**RE: St MATTHEWS CATHOLIC COLLEGE, MUDGEE (SSD 9872)
CORNER BROADHEAD ROAD AND BRUCE ROAD, SPRING FLAT (MUDGEE)
POST RESPONSE TO SUBMISSIONS – REQUEST FOR ADDITIONAL INFORMATION**

I write on behalf of Trustees of the Roman Catholic Church for the Diocese of Bathurst in relation to the current SSD DA for the new St Matthews Catholic College – Secondary Campus at the corner of Broadhead Road and Bruce Road, Spring Flat (Mudgee) and provide a response to requests for further information arising from our Response to Submissions package of early October 2020.

DRAWING TITLE  
INTERSECTION UPGRADE PLAN -  
SHEET 1

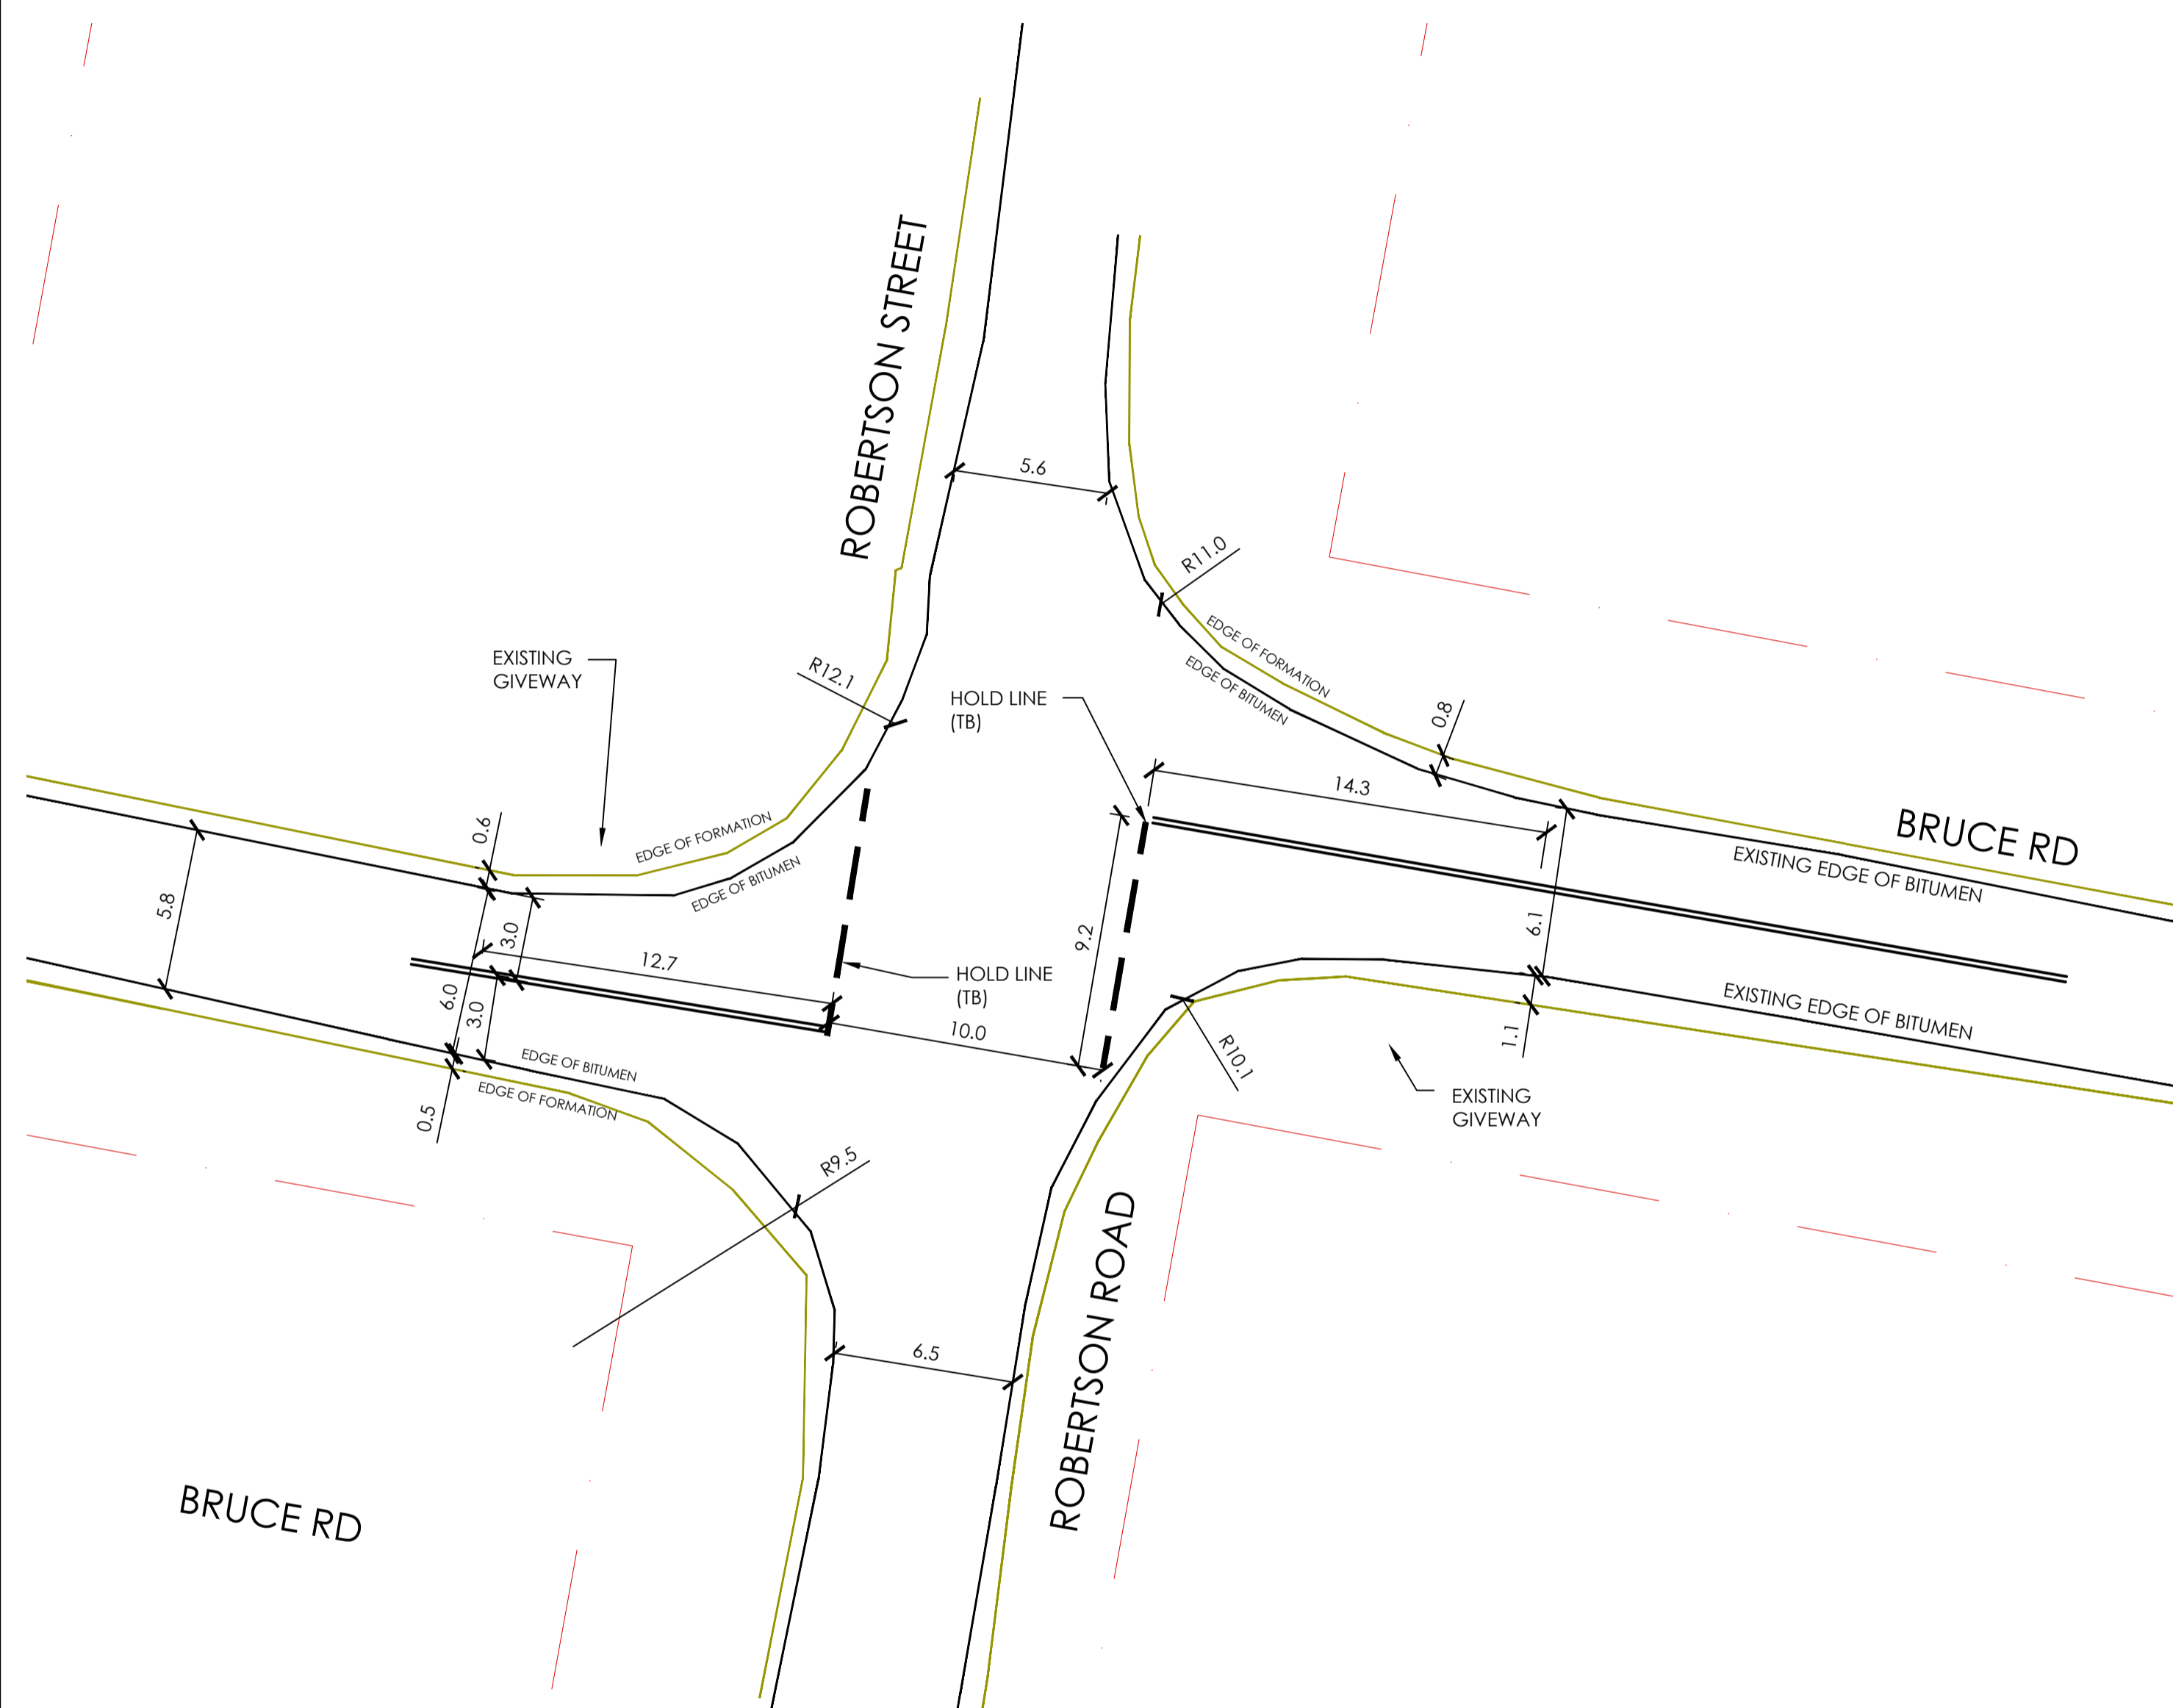
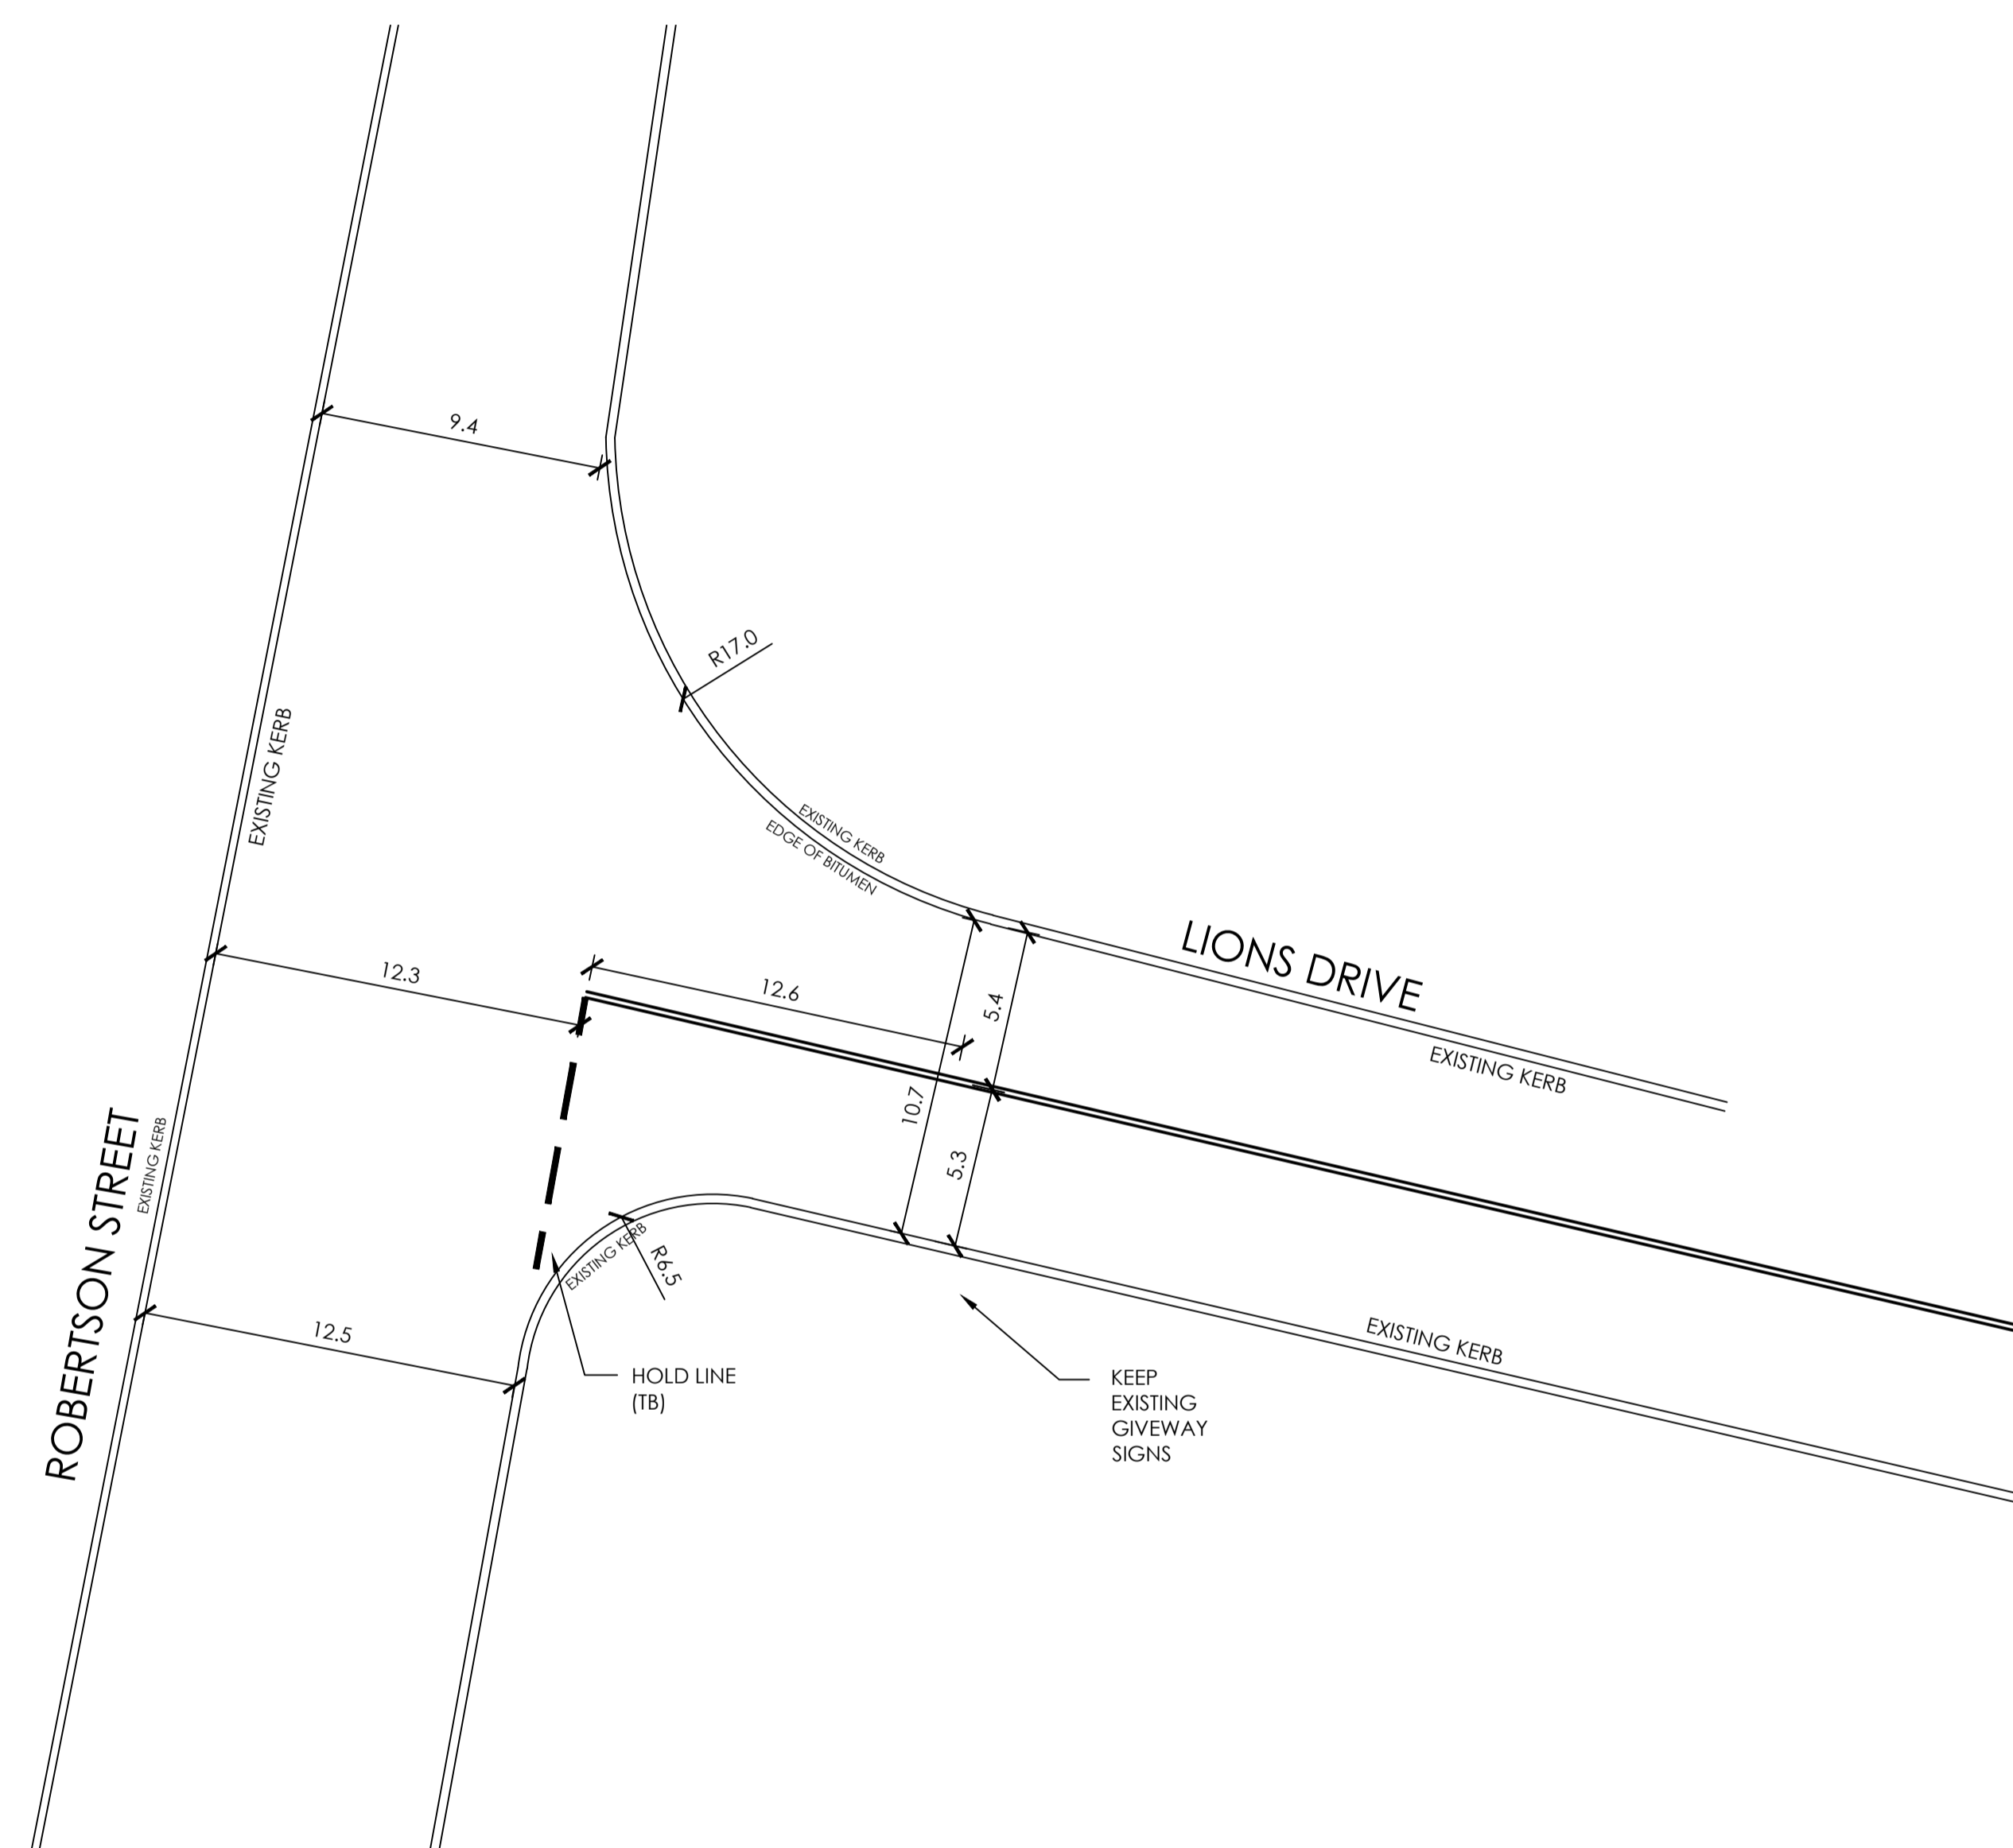
<p><u>Robertson Road / Bruce Road</u> This intersection is a crossroad with Bruce Road through this intersection having an offset alignment. There is no kerb and gutter on any of the pavements and the pavement will require some upgrade prior to line-marking and installation of signage.</p>	<p>Road Upgrades – Broadhead Road <i>Council confirms that the proposed road upgrades as outlined in the EIS and RtS are satisfactory. As per Council’s EIS submission and normal Council practice, it is requested that the final design and detailed drawings are approved by Council prior to commencement of road upgrade works.</i></p>
<p>The revised SIDRA modelling provided indicates that 12% of vehicle access will use Bruce Road east of school and Spring Flat Road. This would suggest that sealing of this road beyond the school abuttal and extending to Spring Flat Road is warranted.</p>	<p>With further respect to the Broadhead / Lions intersection and to confirm, the traffic assessment considers a traffic split of 18% (14% plus 4%) (not the 4% quoted by Council) turning right from Broadhead Road south approach to Lions Drive east approach as shown / highlighted below (Figure 8.2 of the TIA).</p>
